Application No: EP/157/20/HH
Site Address: 29 Tamarisk Way East Preston BN16 2TE
Description of works: Demolition of part of existing garage and outbuildings. Erection of new 3 bay garage. Extensions and internal and external remodelling of existing dwelling including change from thatch to clay tiled roof.

Thank you for your internet representation made on 31st January 2021 which has been recorded as an objection with the comments as follows:

30 January 2021
Ref: EP/157//20/HH

PROPOSED GARAGE PLANS
DRAWING No. 1469/10-
SCALE 1:100 AT A3
© NOVEMBER 2020

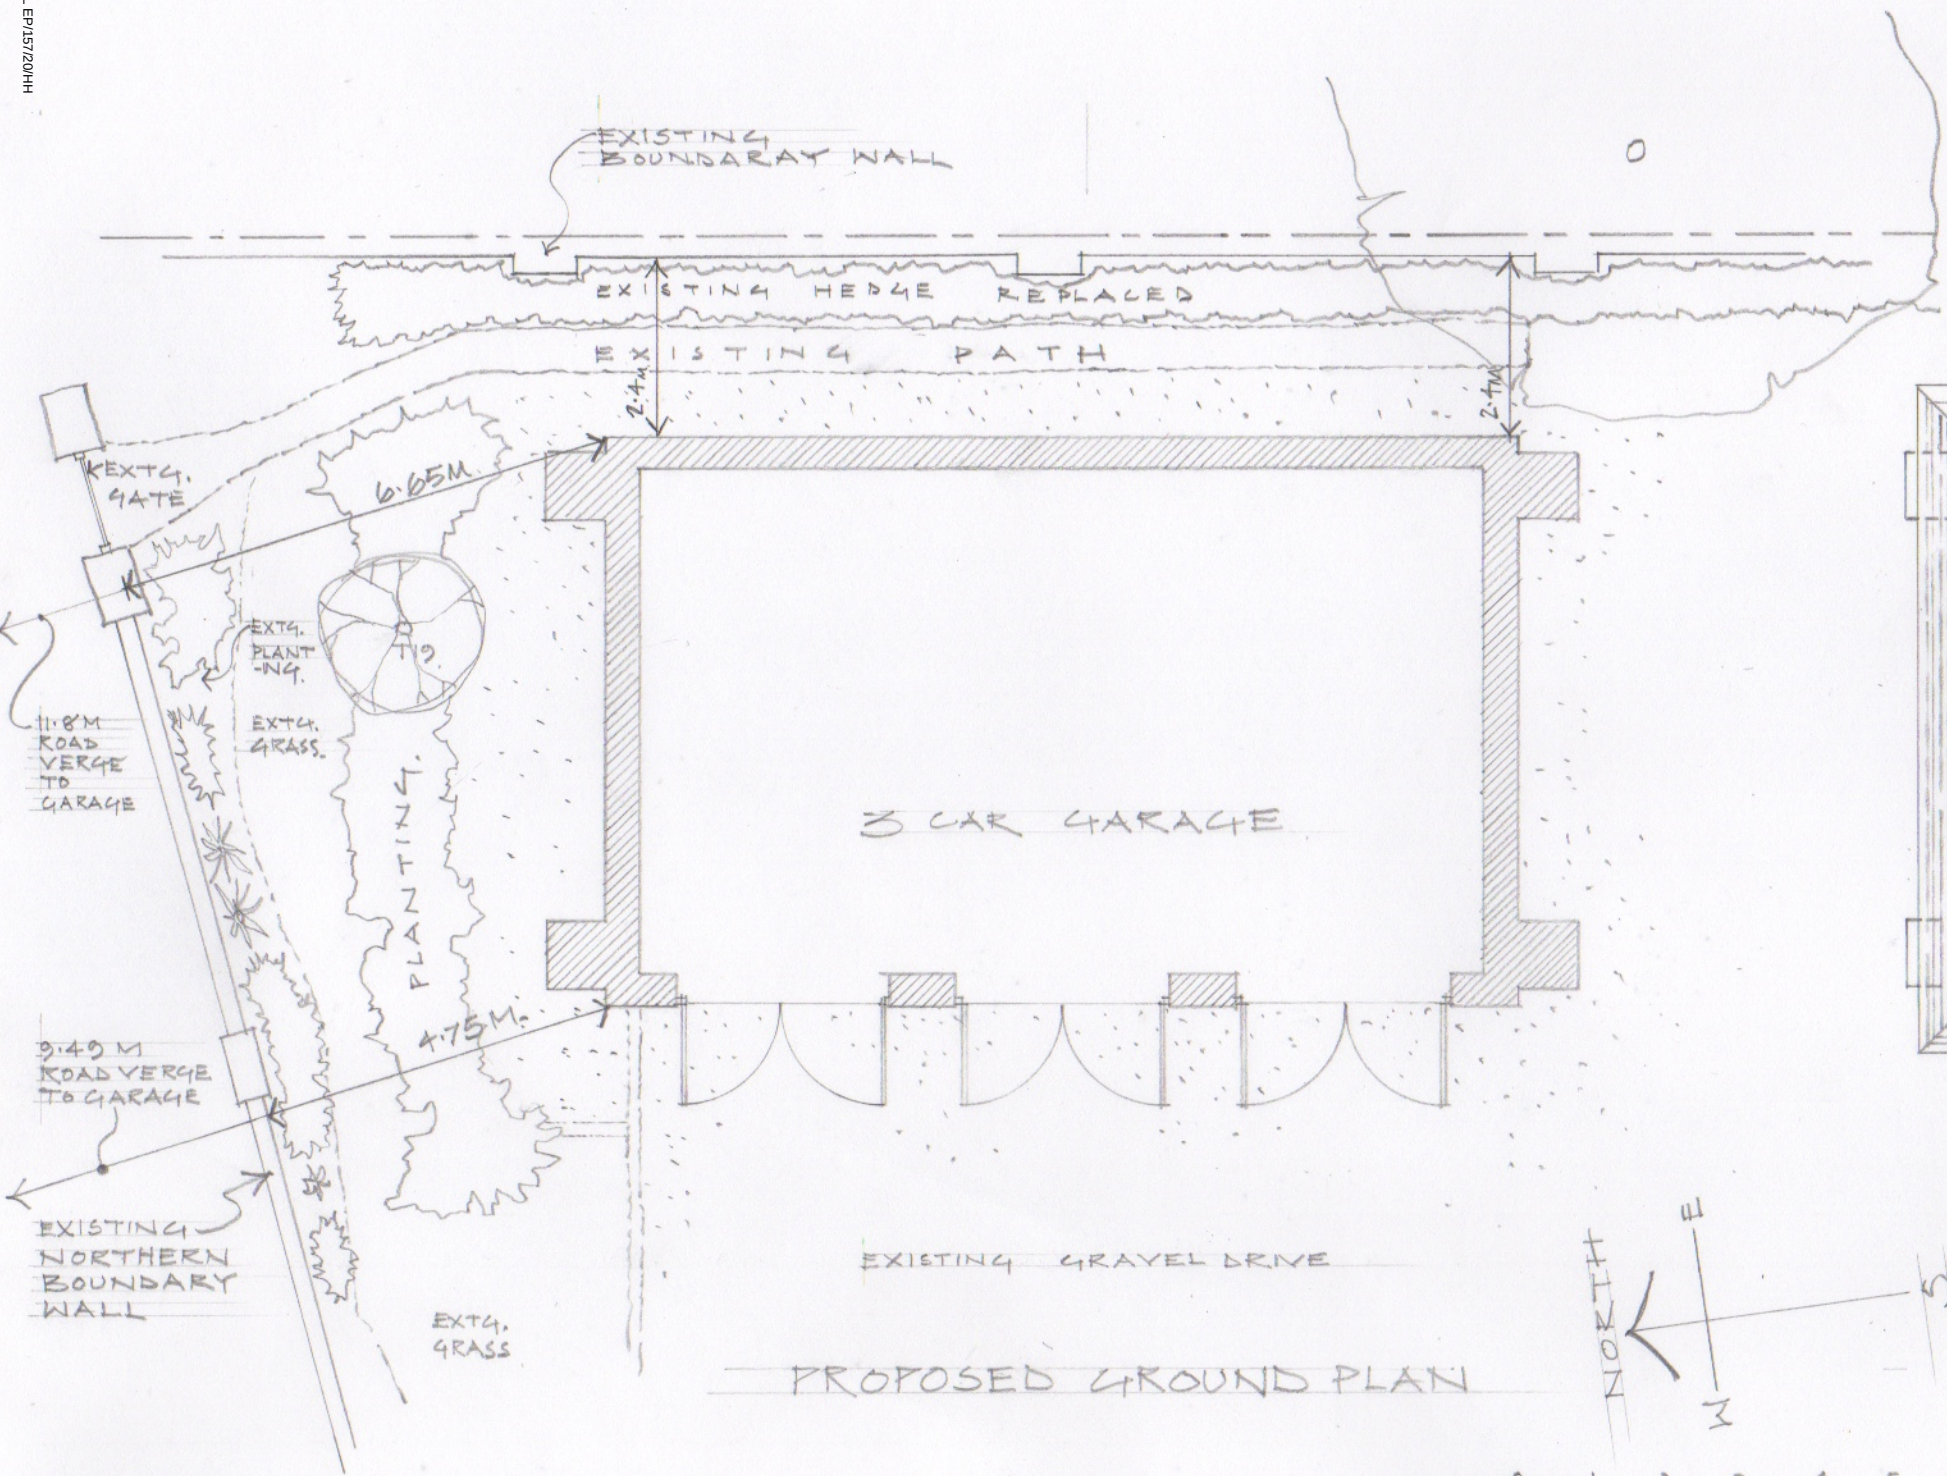
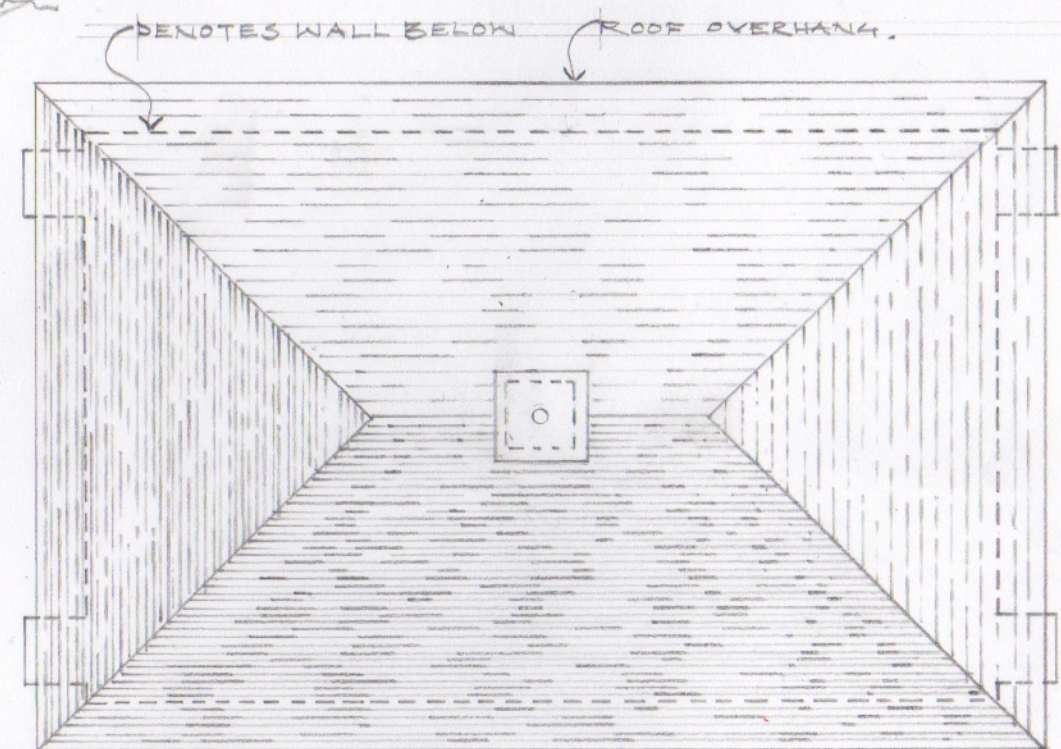
The proposed 3-car garage at 29 Tamarisk Way sits closer to the road than would have been permitted at the time of our build.
